From: David Elmore
Sent: 18 May 2018 15:16
To: Planning
Subject: FW: Consultation response for planning application. 6/2018/0804/FULL

I have taken a look at the above proposal with regard to the impact on the landscape and character of the area.

Title
**SITE PLAN - PROPOSED
SHOWING ROOT PROTECTION
AREAS**

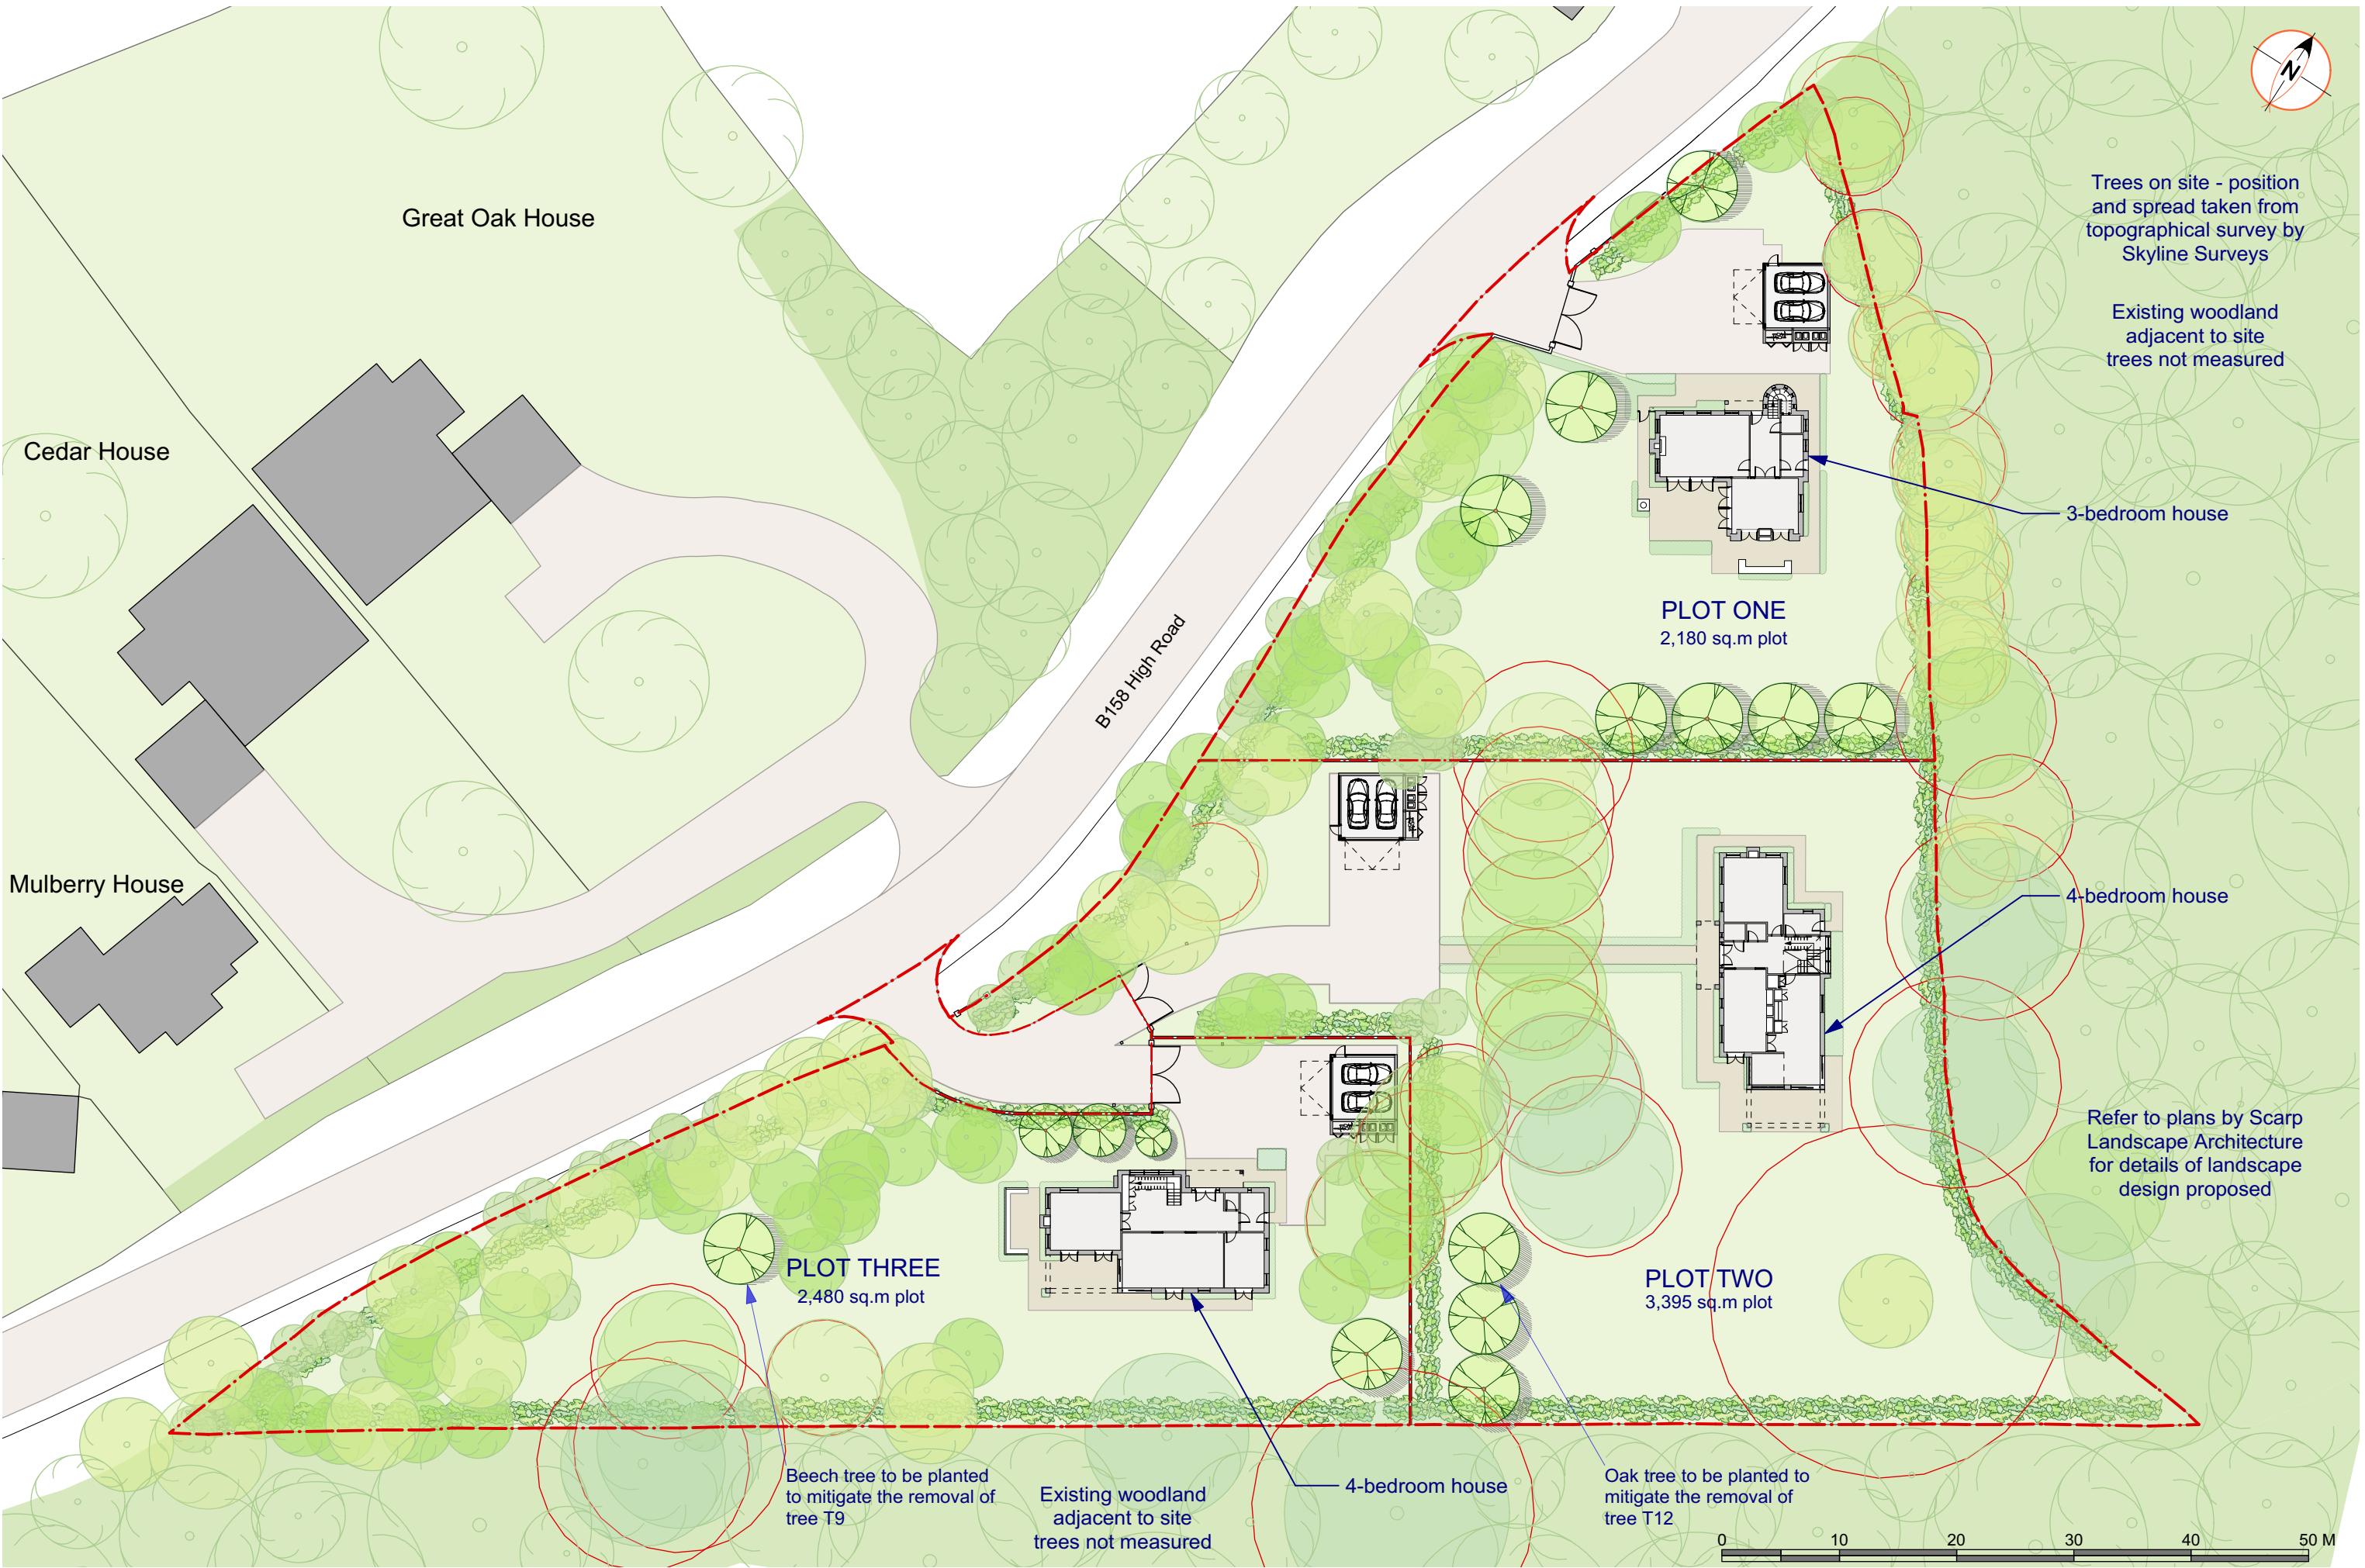
The site is well treed site with some significant trees and groups of trees within it. The arboricultural report supplied has categorised the trees in accordance with BS:5837: 2012, the categorisation is considered a fair assessment of the trees. I understand that there is an existing permission for two dwellings and this current proposal is for three dwellings in total. This current proposal requires the removal B Category trees (good quality), however given the location of the trees in the centre of the site their removal will have little impact on the character of the area and replacement planting elsewhere on the site, will over time, mitigate the loss of these trees.

The proposed landscaping for the site is considered appropriate and sufficient for the site. If approved it is recommended that a condition be attached requiring that any plant/tree failures are replaced within the first five years following the planting of the scheme.

scheme: The Spinney, High Road,
Essendon, Herts, AL9 6HP
client: Essendon Property Ventures Ltd
drawing: Tree Protection Plan
date: 04.03.2016
scale: 1:250@A1
dwg no: PR119764-03B
drawn: TRG checked: A Bigg

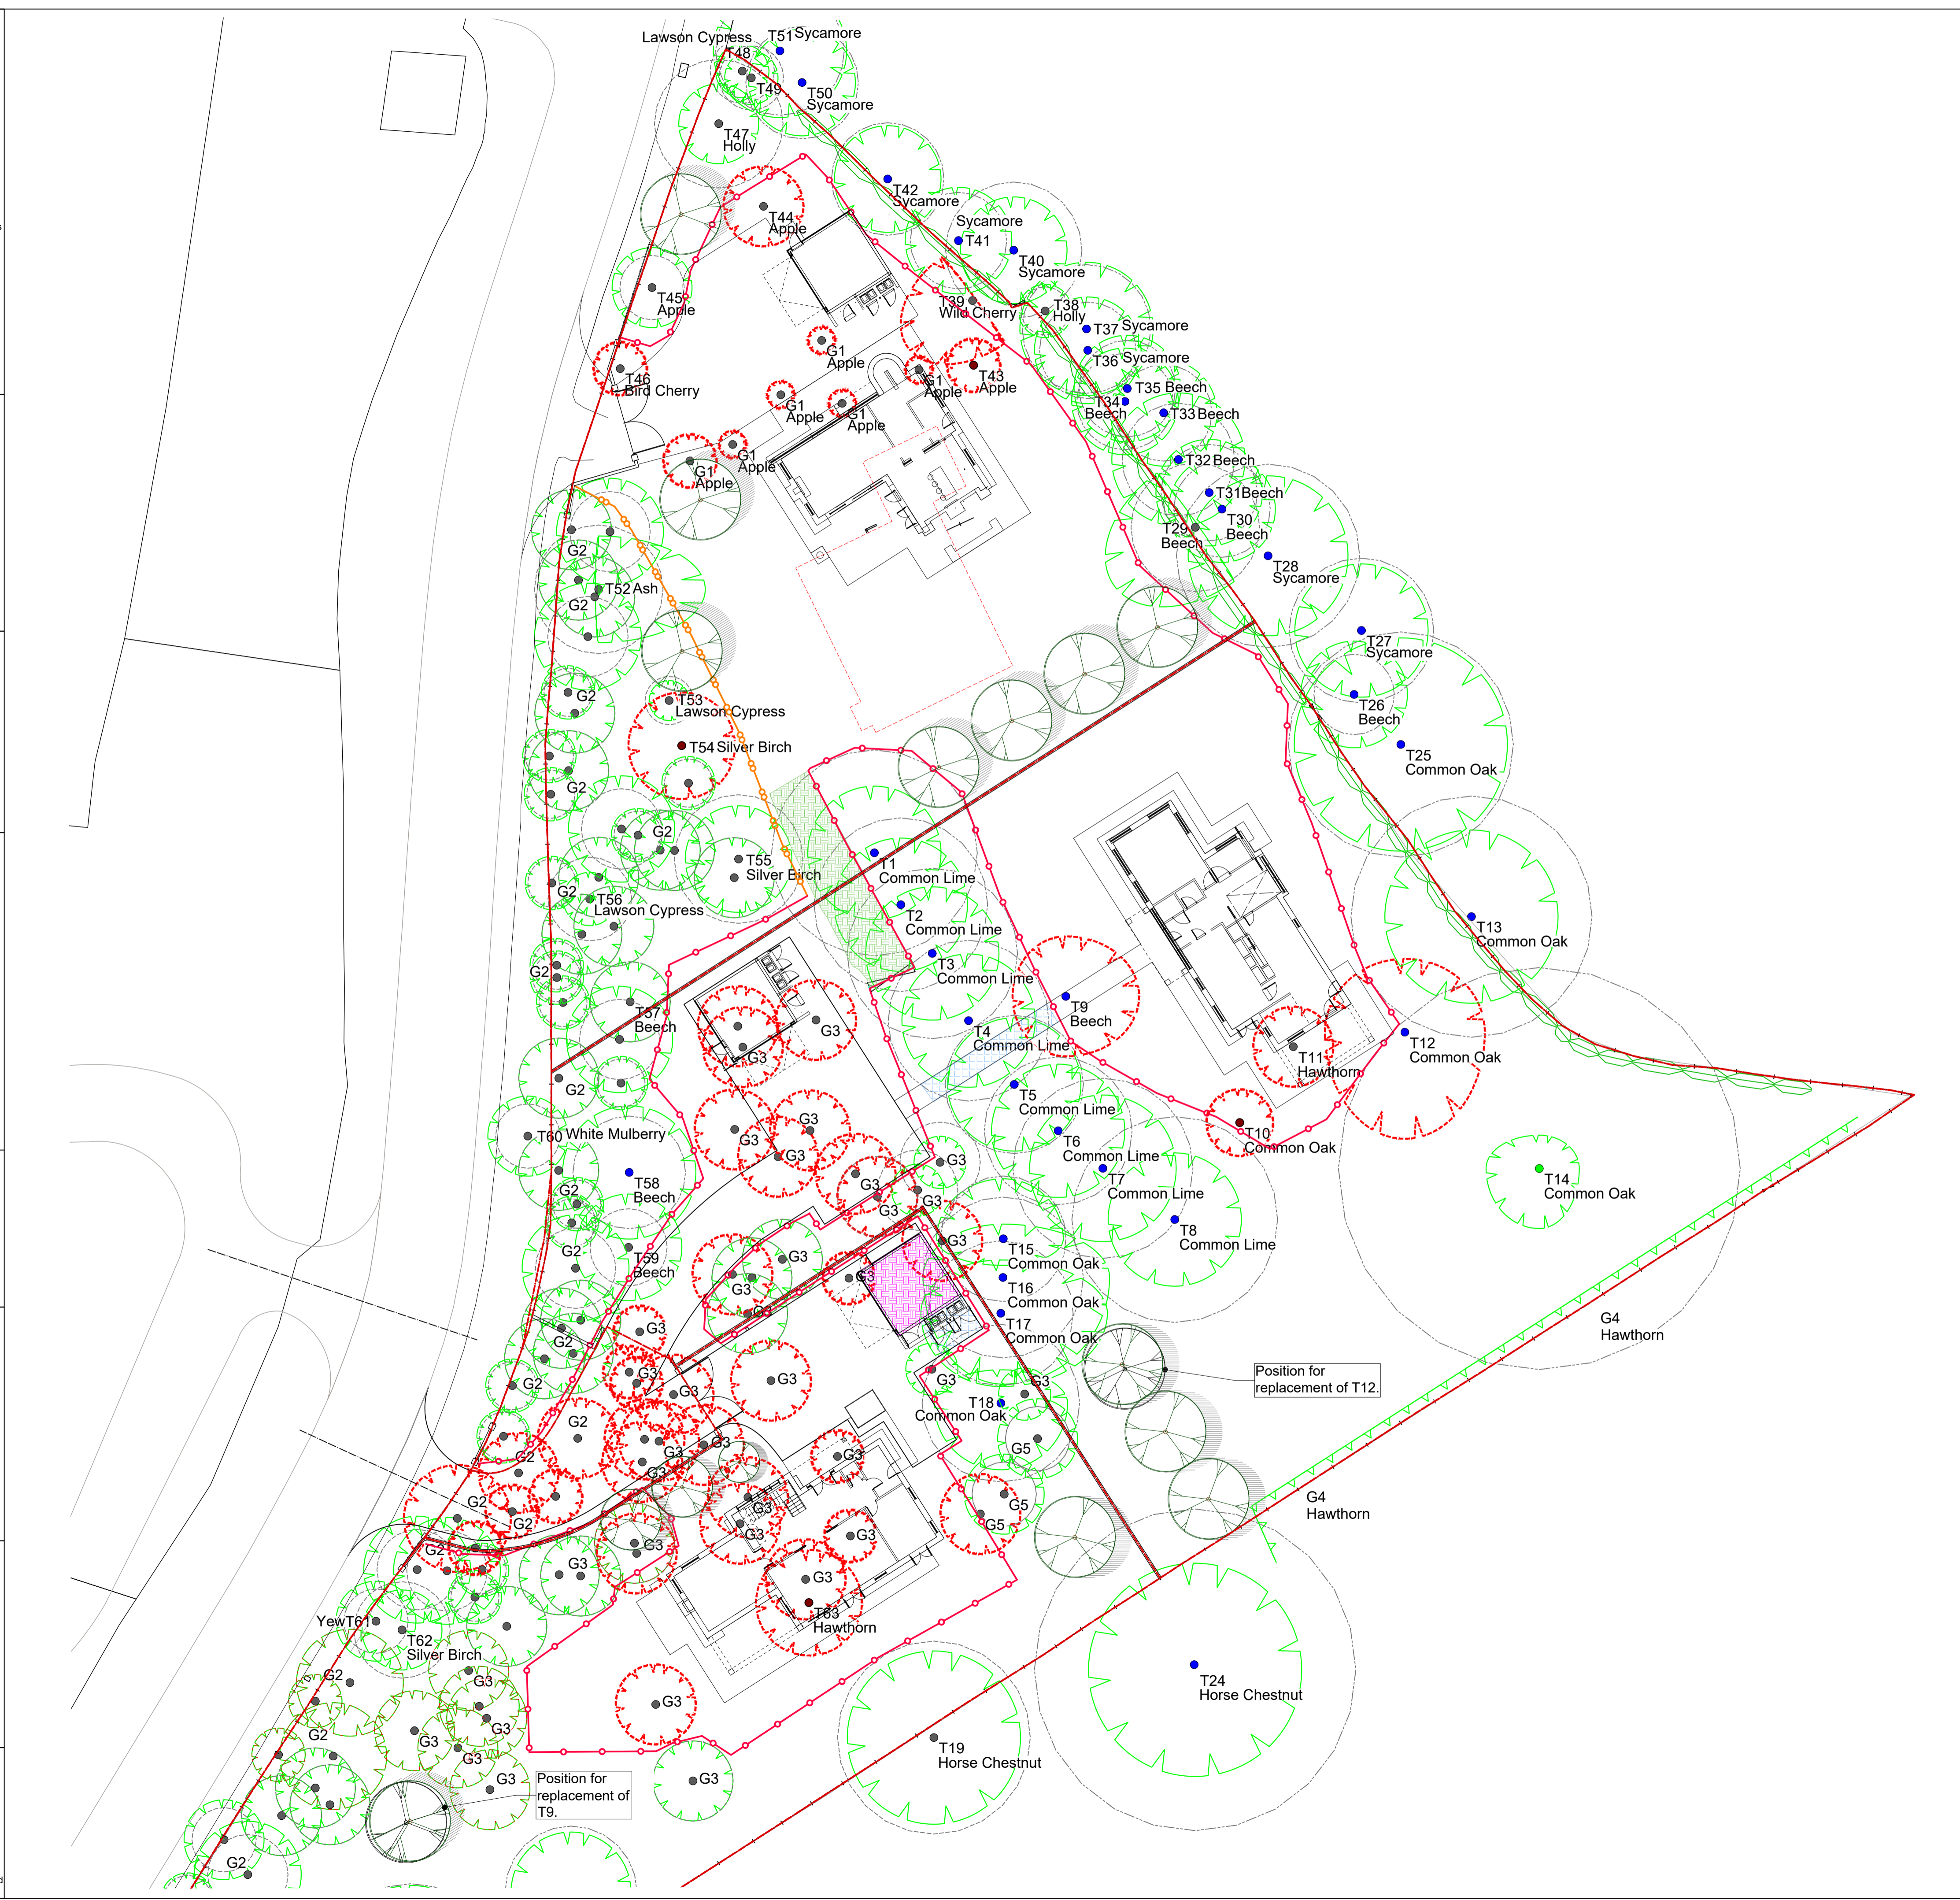
The Arboricultural method statement supplied gives clear procedures, in the form of fencing, ground protection and construction methods, to protect the retained trees throughout the development. the method statement is considered robust and sufficient to protect the trees.

In conclusion there is no objection to the proposal on landscape grounds with the proviso that the arboricultural method statement and landscape scheme are adhered to fully.
